MERIDIAN STORAGE

GRADING & EROSION CONTROL PLANS

SF-23-XXX VR239

EPC STORMWATER REVIEW COMMENTS
IN ORANGE BOXES WITH BLACK TEXT

INITIAL EROSION CONTROL PLAN

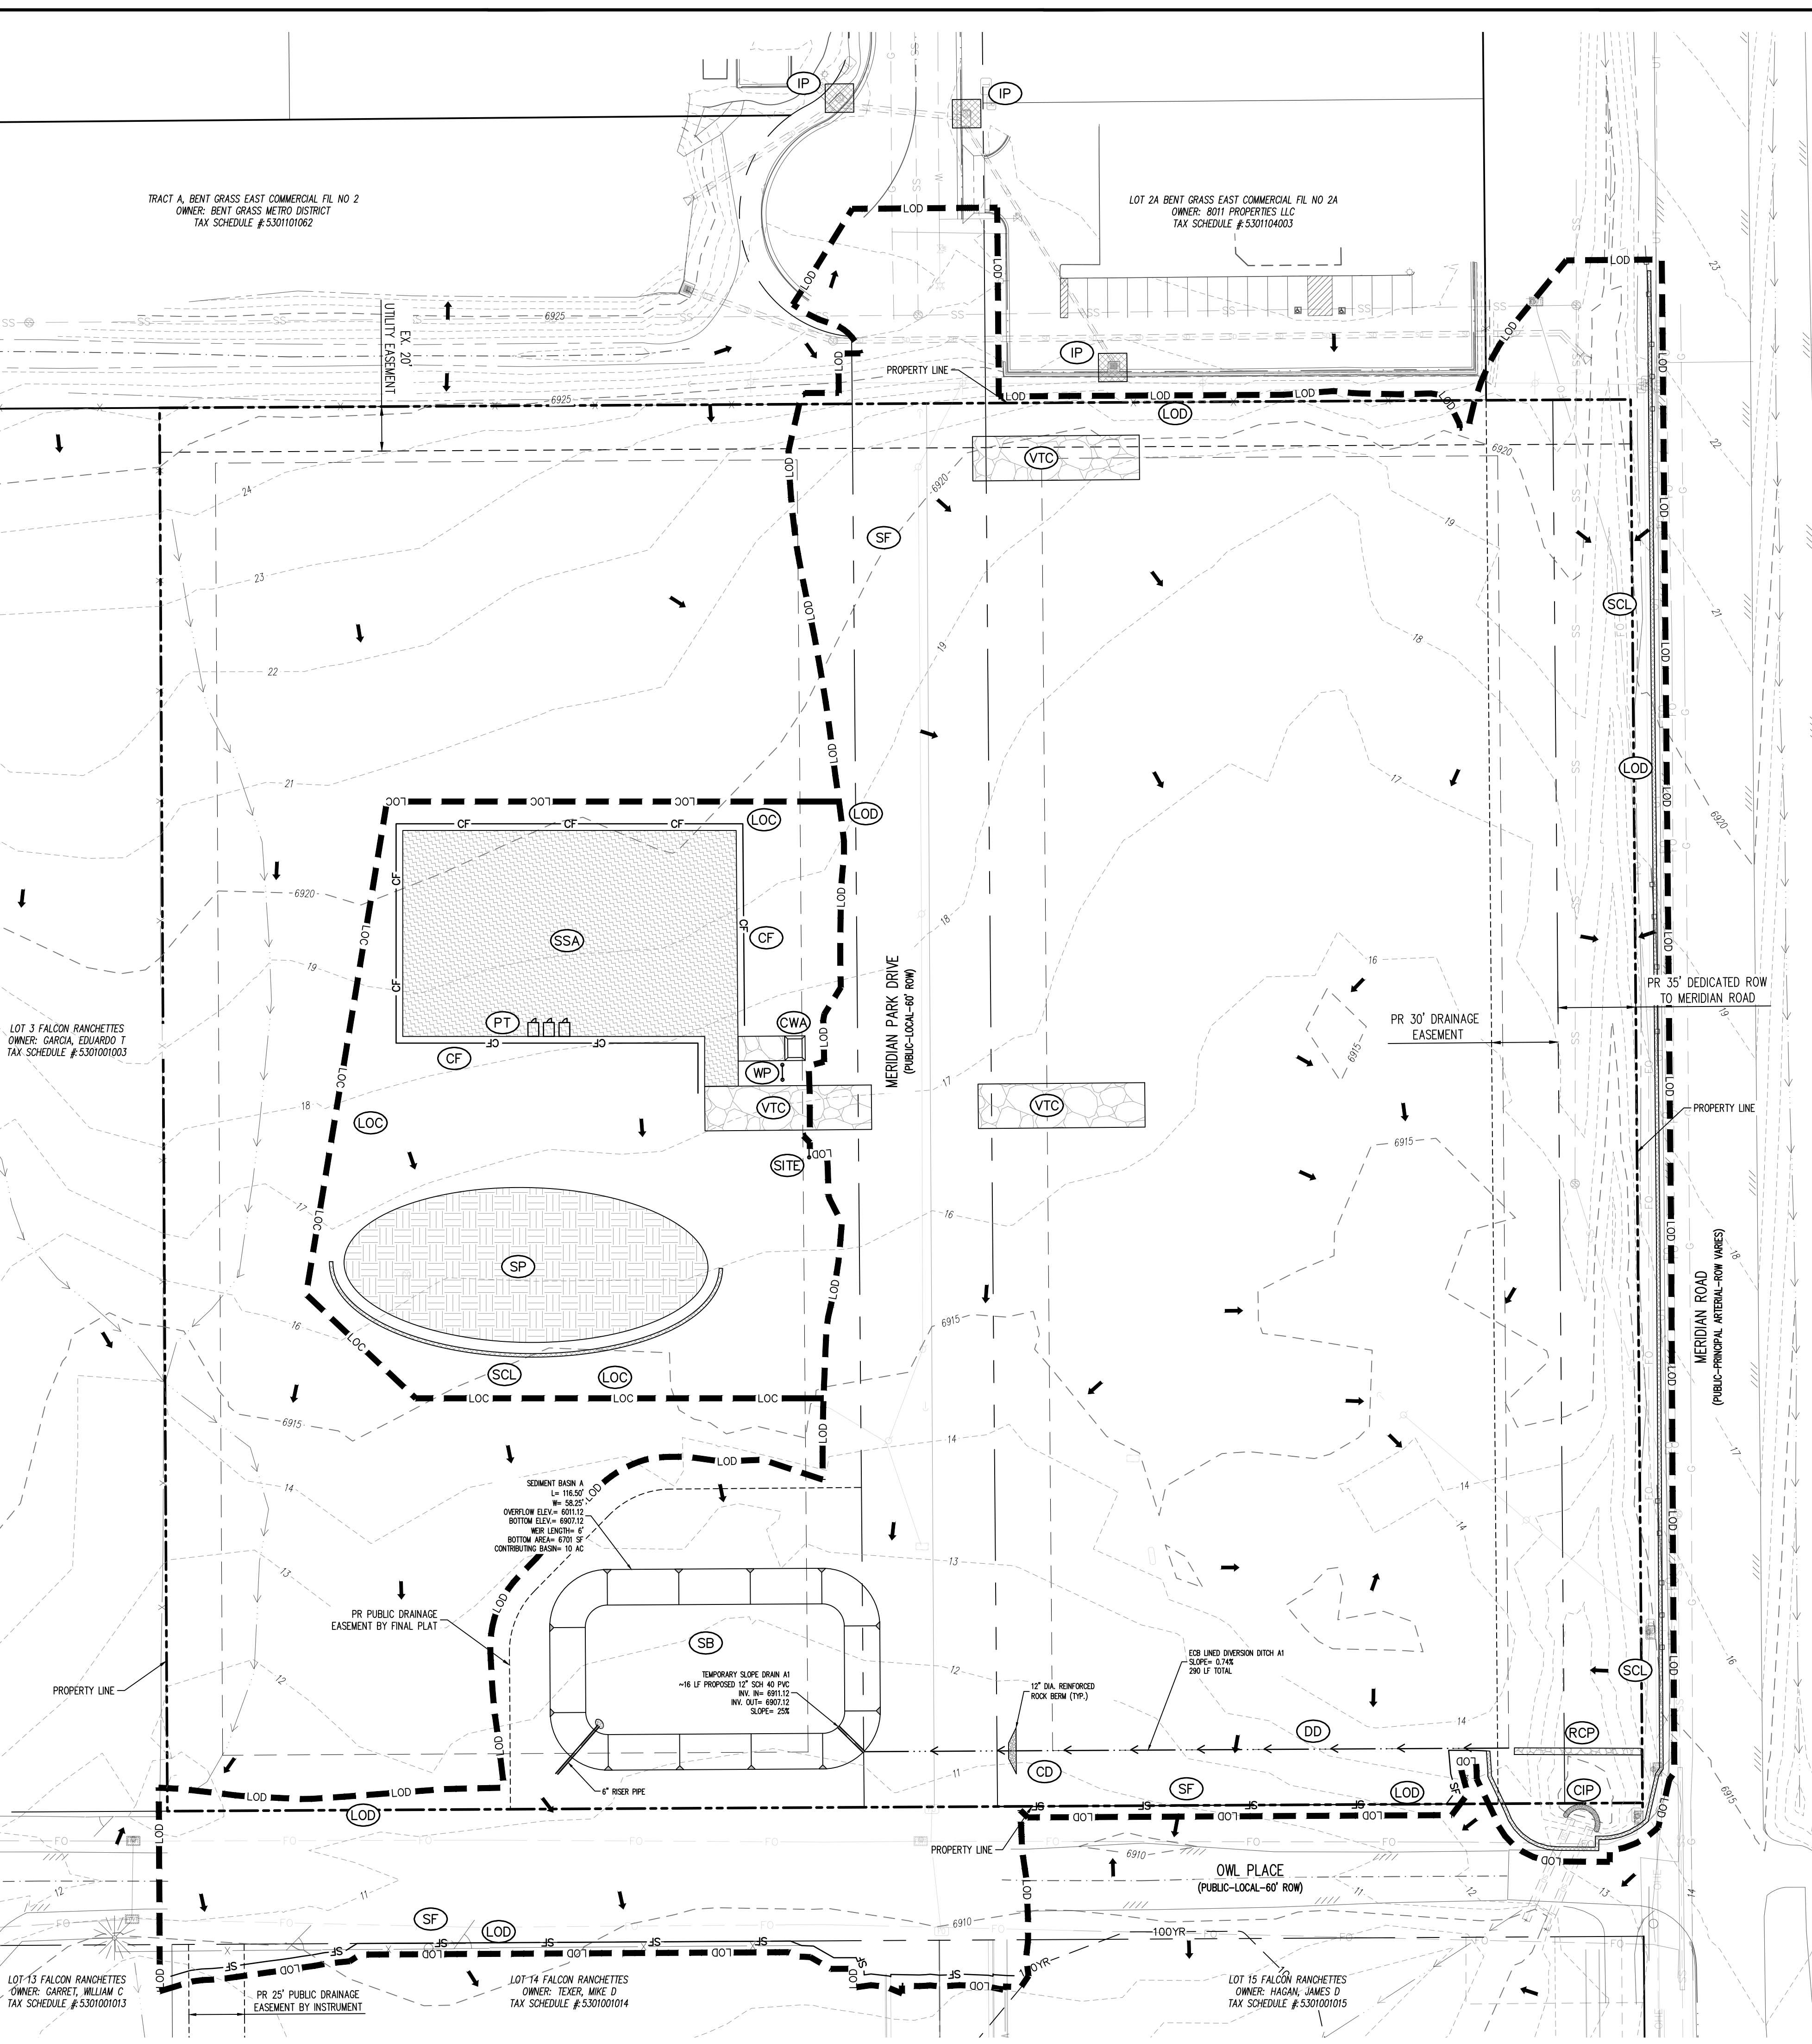
is SCL necessary? if not, please remove. concerns with SCL preventing Meridian road from draining properly during construction.

add construction fence to protect the public

how will the Site be accessed? VTC(s) should be located at Site entrance/exit locations. Provide construction fencing, barricades, and/or signage at access points not to be used for construction.

add construction fence to protect the public

show DD contours or include a typical DD cross section

Add RCP to the legend.

INTERIM EROSION CONTROL PLAN

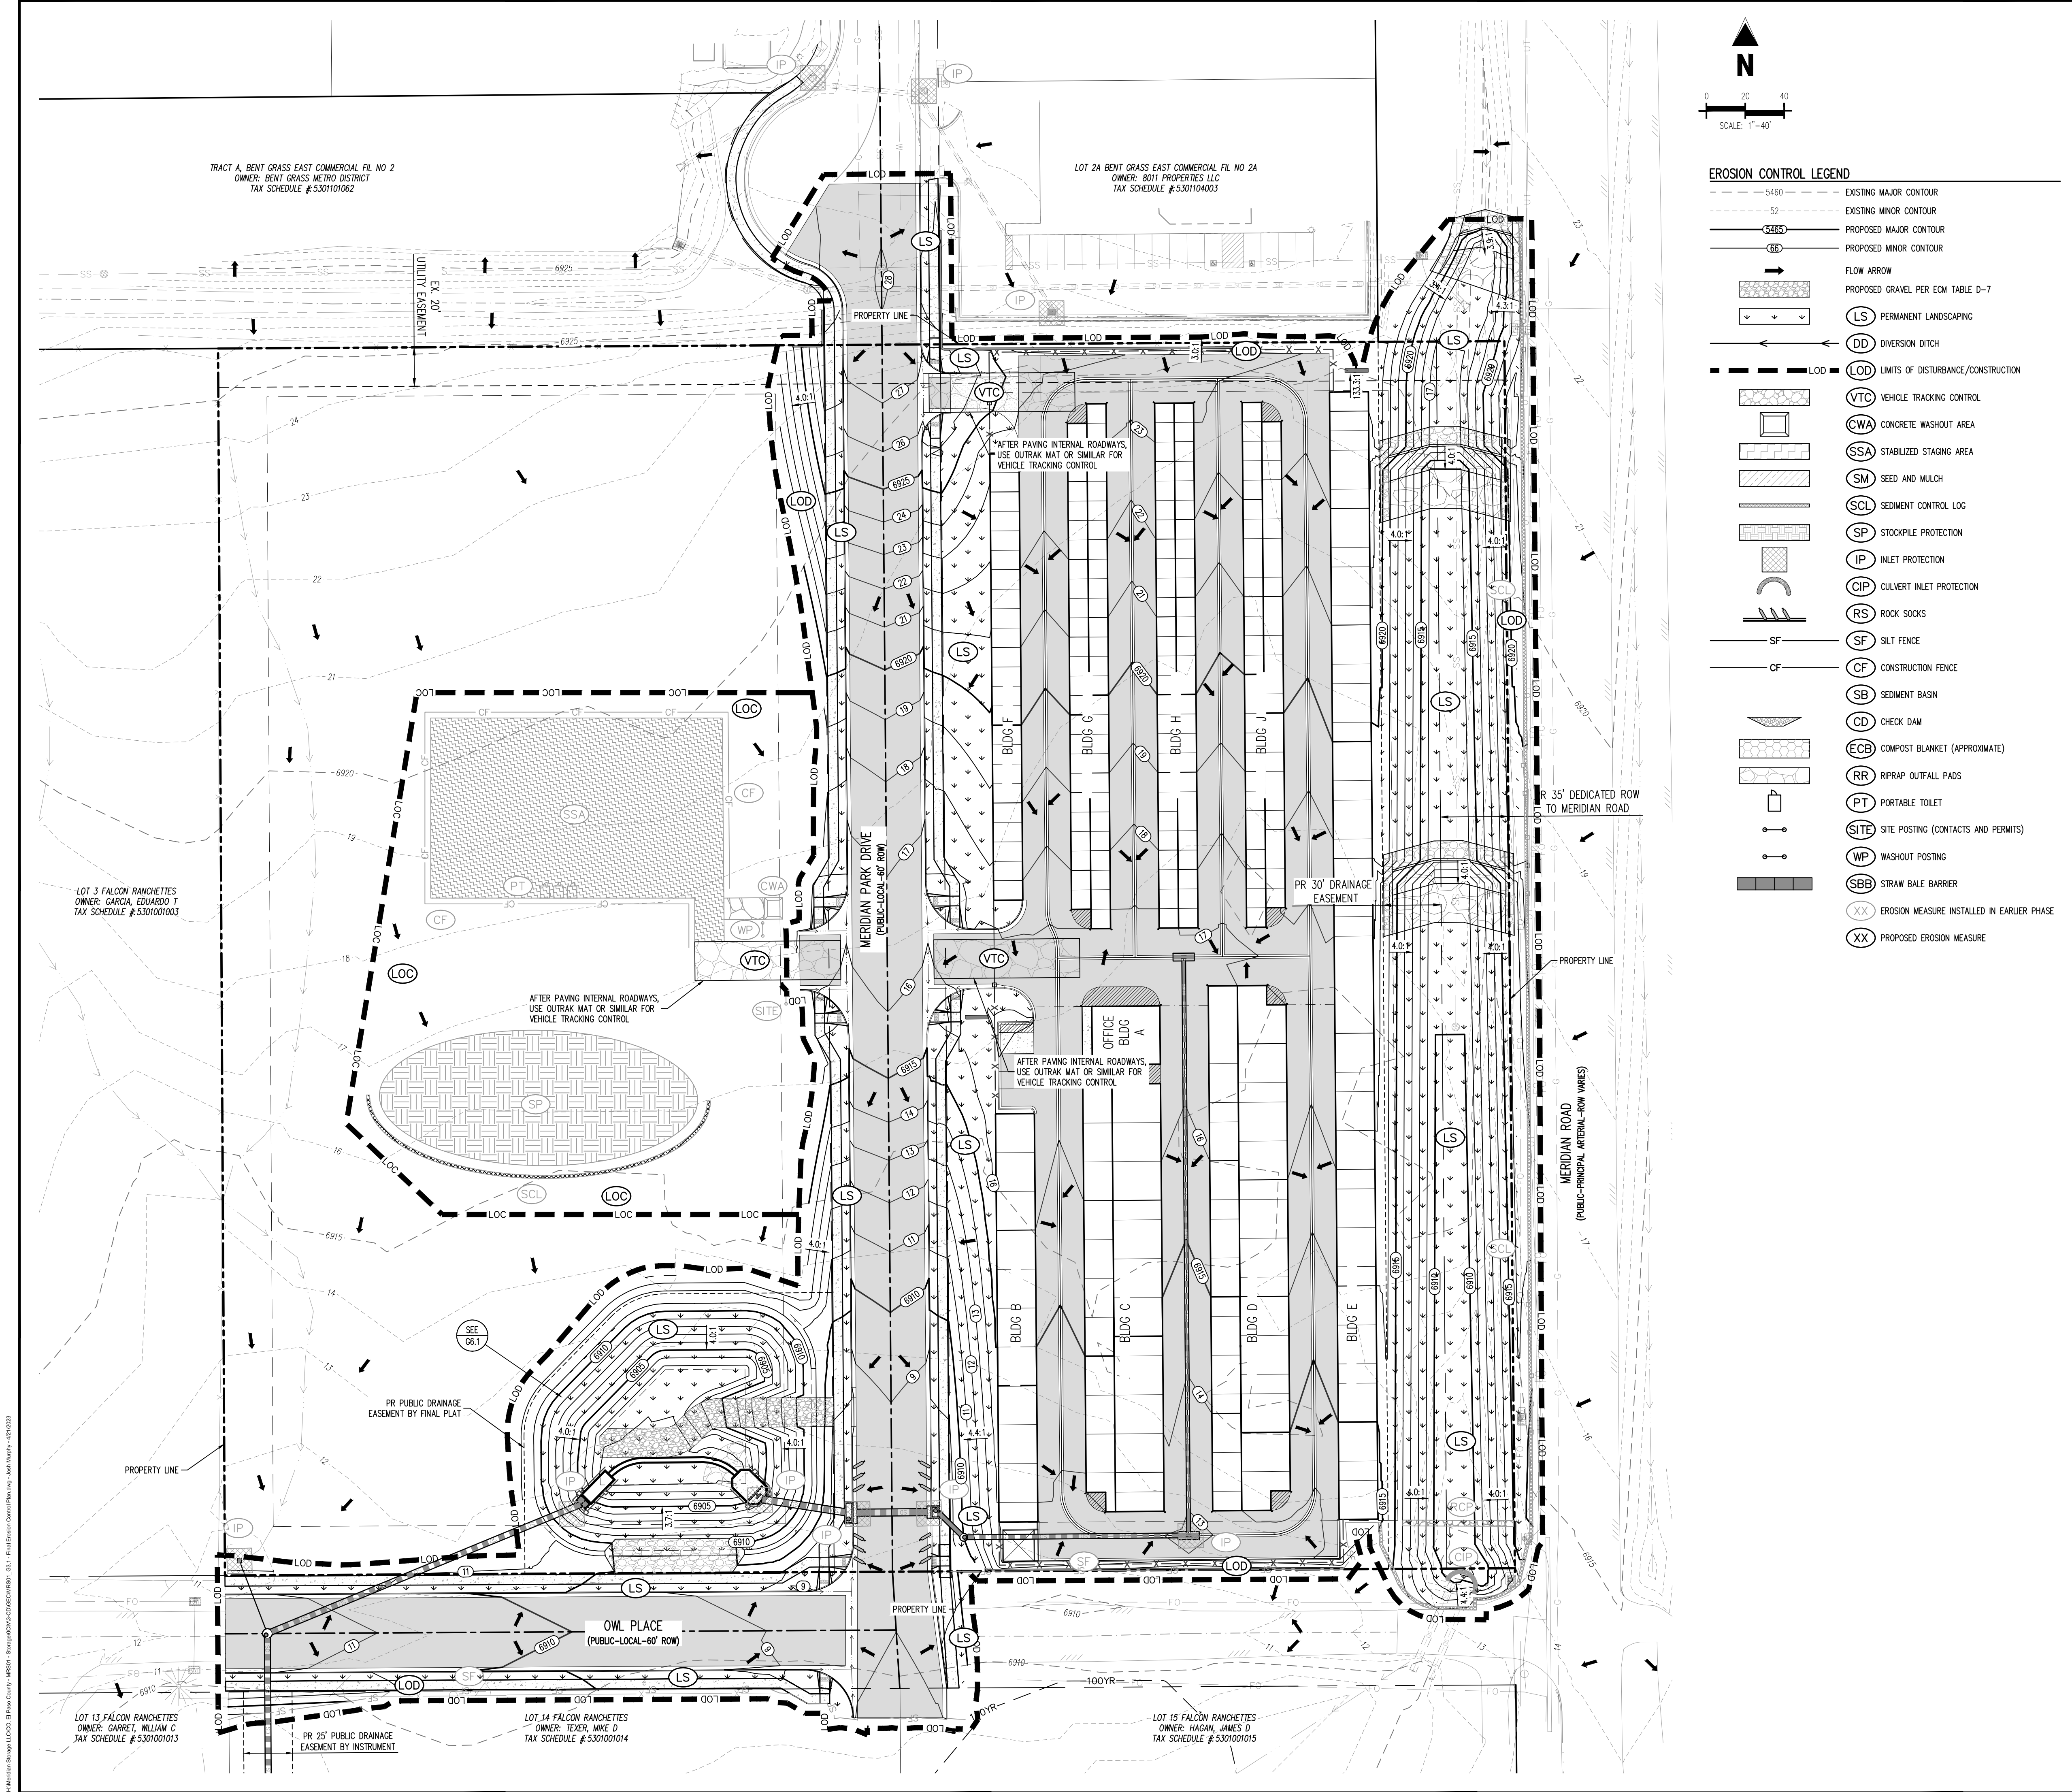
CD indicates 32.5 easement on one of the sheets. Make sure they are consistent with each other.

install additional rock check dams to prevent sediment migration until 70% vegetation is achieved.
